Appeal NO: ABP 315708-24Defer Re O/H ☐

OBSERVATIONS RE: ABP-315708-23
PLANNING REFERENCE 22/50933

(1) DEMOLITION OF EXISTING CONCRETE STRUCTURE (2) QUARRYING OF 5.37 HECTARES WHICH WILL BE SUBJECT TO EXTRACTION AND PROCESSING OF ROCK THROUGH DRILLING, BLASTING, CRUSHING AND SCREENING (3) CONSTRUCTION OF (A) SETTLEMENT PONDS AND WETLAND (B) A SHED FOR THE PURPOSES OF STORAGE FOR THE FACILITY INCLUDING ON-SITE MACHINERY MAINTENANCE (C) SITE OFFICE WITH CANTEEN, TOILET & DRYING FACILITIES (4) INSTALLATION OF A WASTEWATER TREATMENT SYSTEM & PERCOLATION AREA (5) PROVISION OF A WHEEL WASH AND WEIGHBRIDGE (5) LANDSCAPING OF THE QUARRY DURING THE OPERATIONAL PHASE AND RESTORATION OF THE QUARRY ON COMPLETION OF EXTRACTION (5) ALL ASSOCIATED ANCILLARY FACILITIES / WORKS OVER A 25 YEAR PERIOD.

Job Number 19280 Dwg Number 09

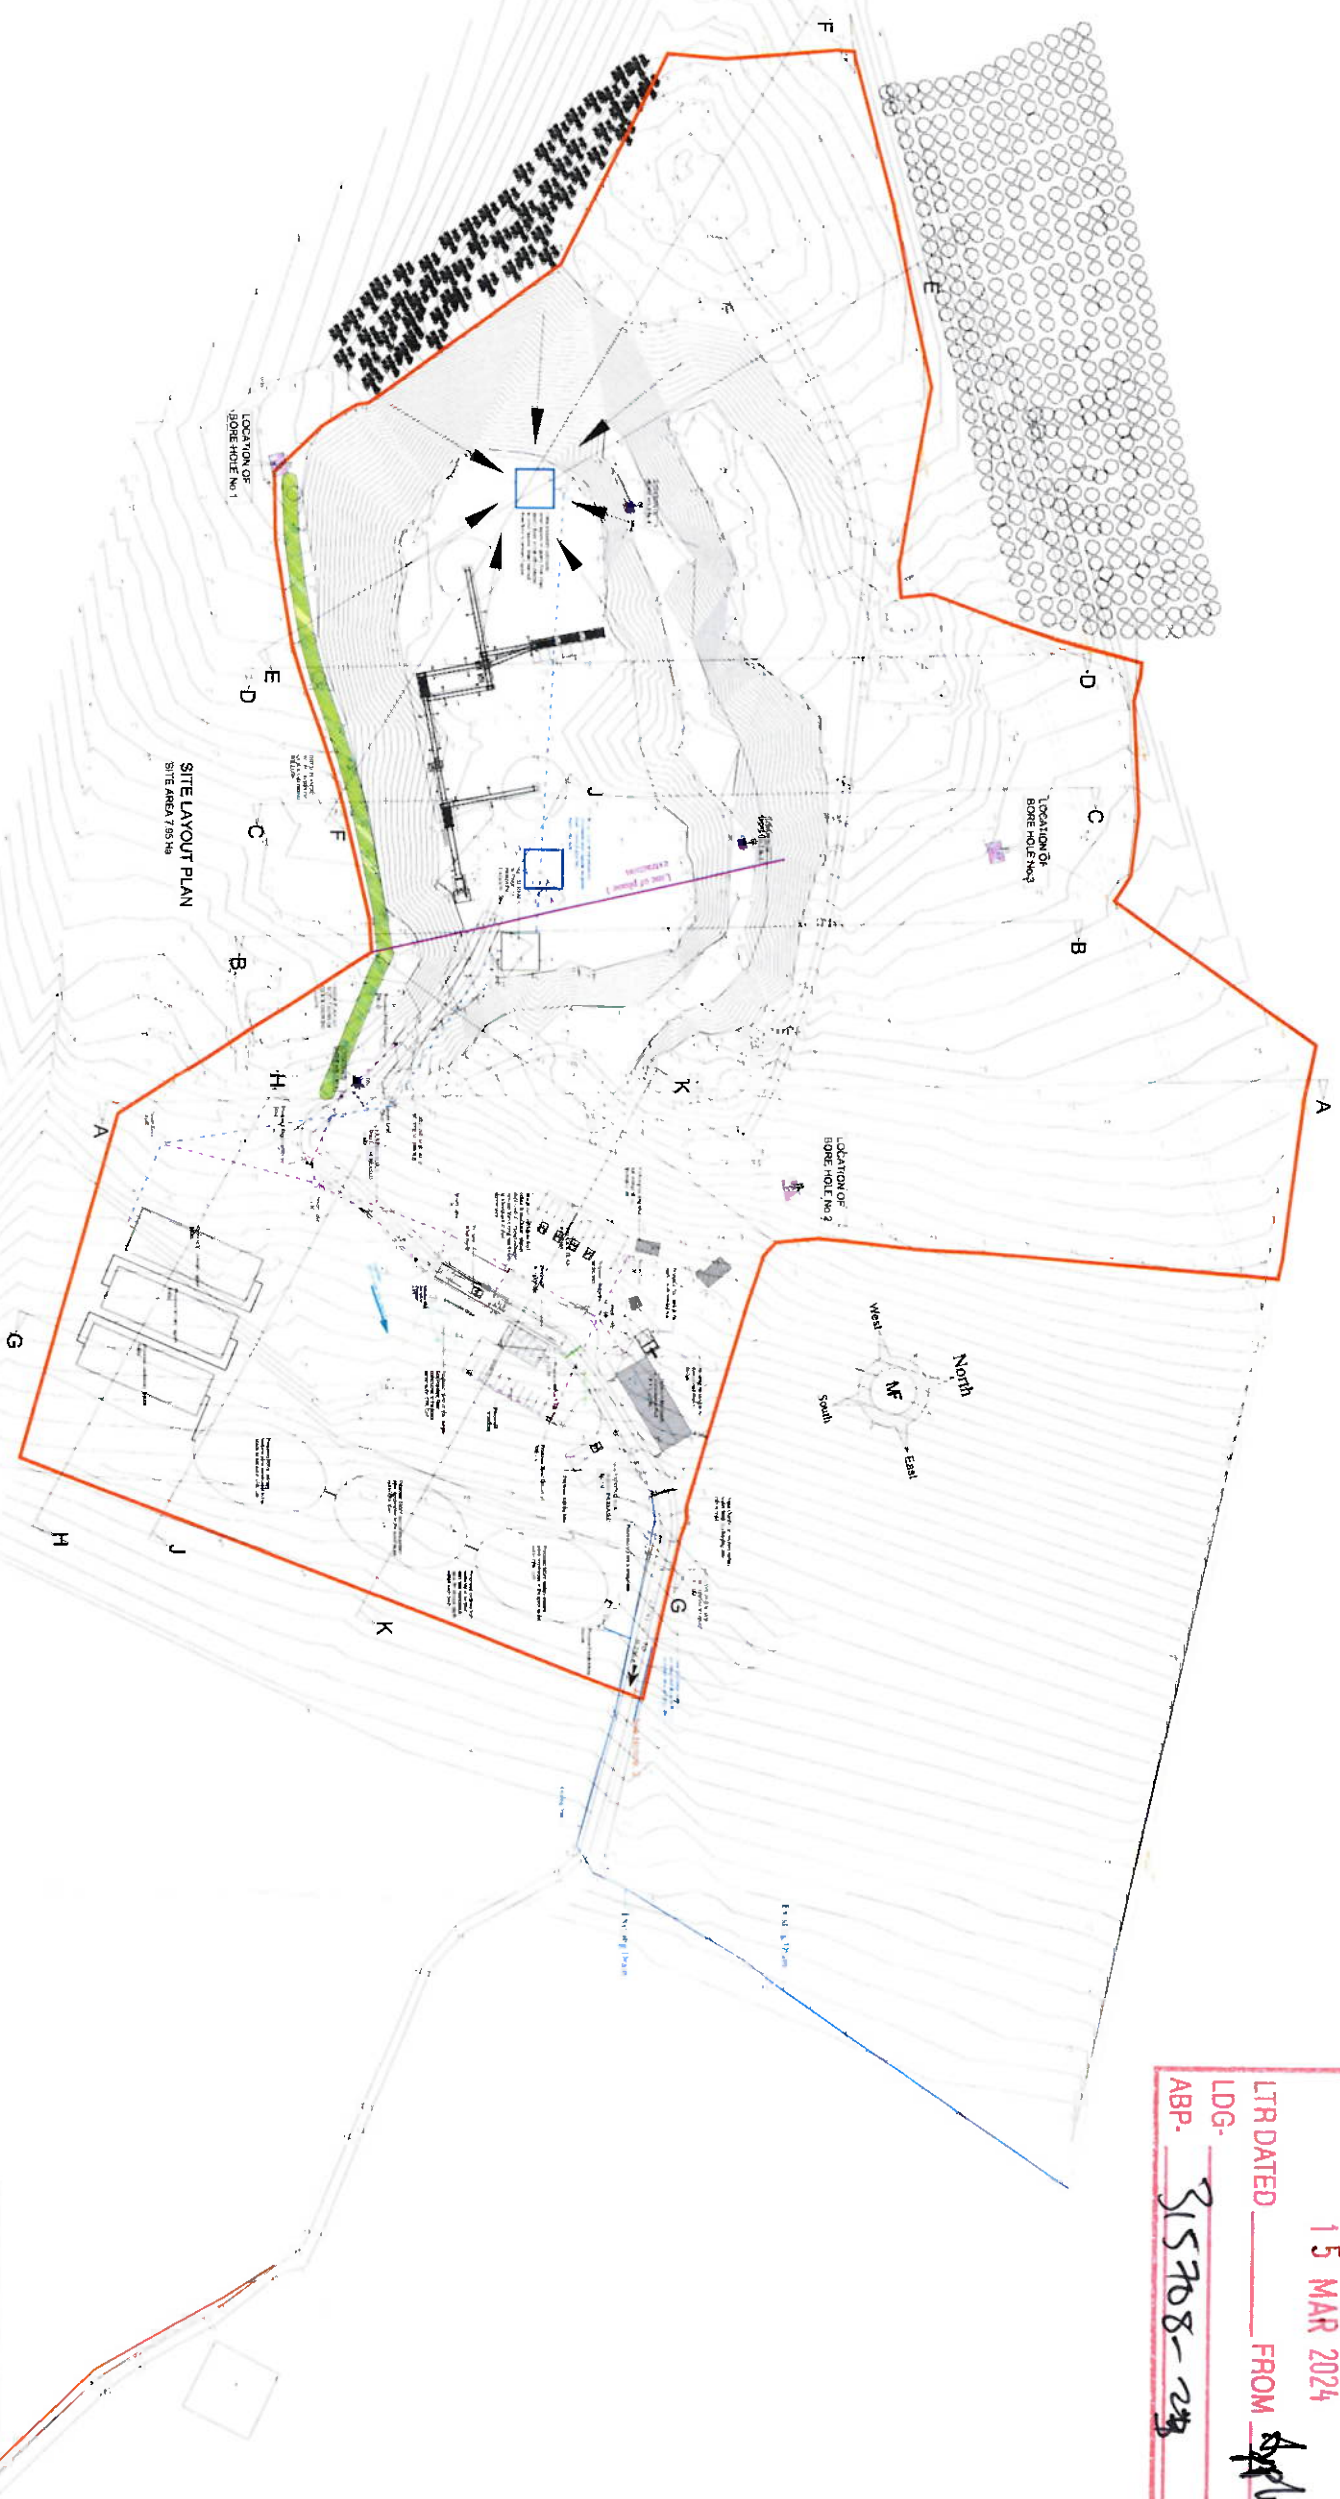
Regarding the cover letter by Michael Friel and the drawings in appendix. 4 within the response to the board, the passing lanes provided by the landowner aren't really the issue. Of course the landowner will make this provision, even though the homeowner at the bottom of the lane will be faced with a new parcel of land against his wishes. Realigning the existing L-23749-0 where it meets the busy R236 road that runs into Raphoe town (where the site notice should have been placed) is also substandard. A 72m sightline in both directions is not sufficient, especially when reliant on hedge maintenance.

Depending on how the guidelines are read, sightlines of at least 120m should be achieved on a regional road. One could argue that 160m is more appropriate, but 72m is nowhere near what should be sought. One sightline crosses into the 50kmph speed limit zone of Raphoe town and onto a heavily used footpath where people from the town, and students from the schools do a 1-mile walk on a daily basis. The other sightline looking left on the R236 is onto a long straight where the speed limit is rarely adhered to. There has already been a fatal traffic collision on this stretch of road and many more KSI collisions. The danger is added to at this point by the presence of a junction with L-2374-4. All things considered; this has the potential to be a deathtrap, and a very good reason to reject this proposal, where safety is so clearly compromised.
